Application for a Non-Material Amendment Following a Grant of Planning Permission

Land adjacent to Inkerman Court, Barnsley Road, Denby Dale, Huddersfield

Erection of 6 Dwellings (Modified Proposal)

2023/62/92871/E

HOUSE TYPE U1 1903-HT-U1-01A
BARNSELEY ROAD, DENBY DALE
YORKSHIRE COUNTRY PROPERTIES
SCALE:1:100@A3 - FEB 2024

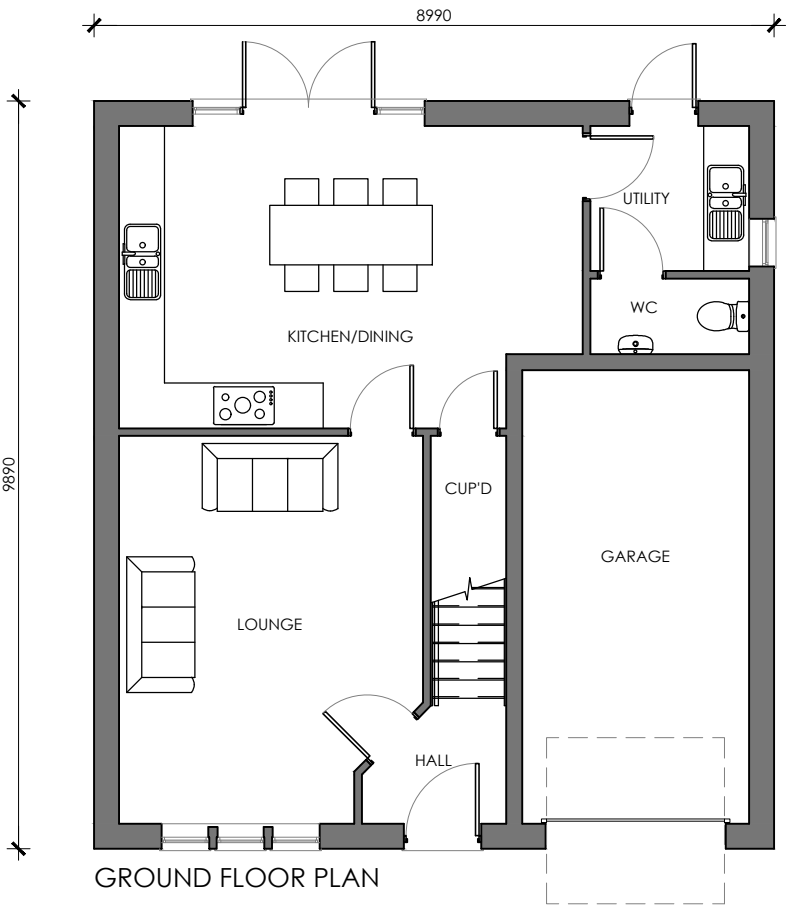
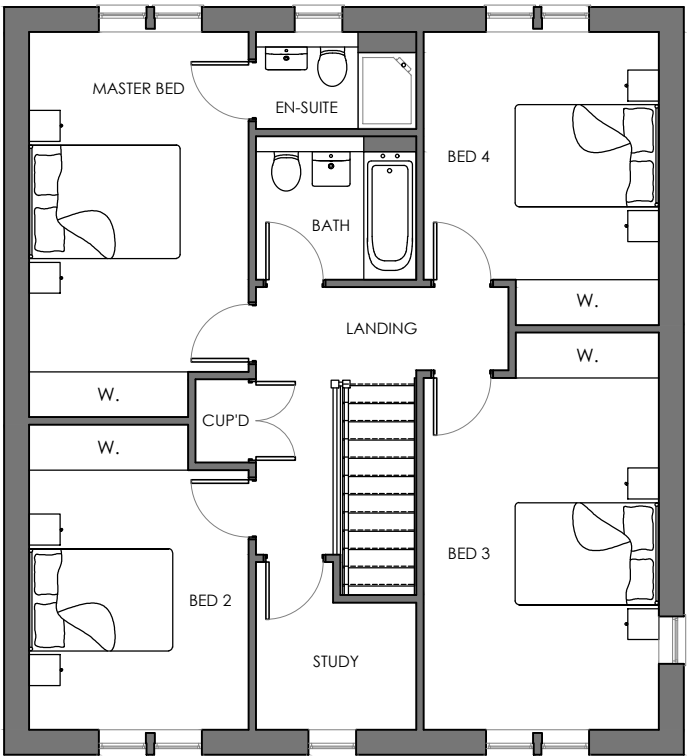
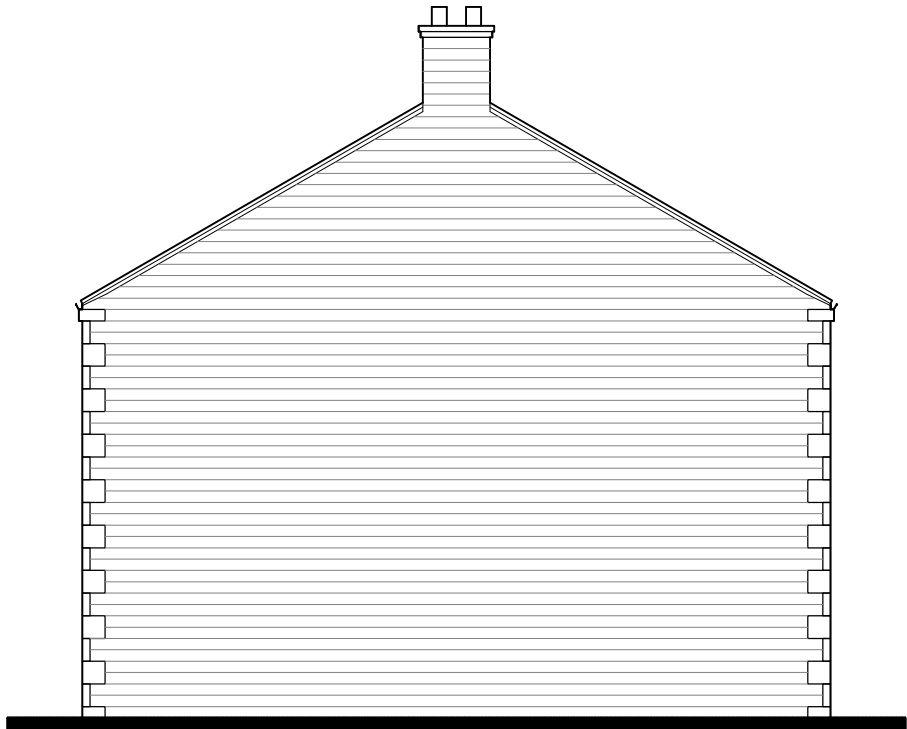
U1 Housetype.
2no. windows added to Utility and Bed 3 on side elevation.

Additional windows to satisfy SAP assessment.
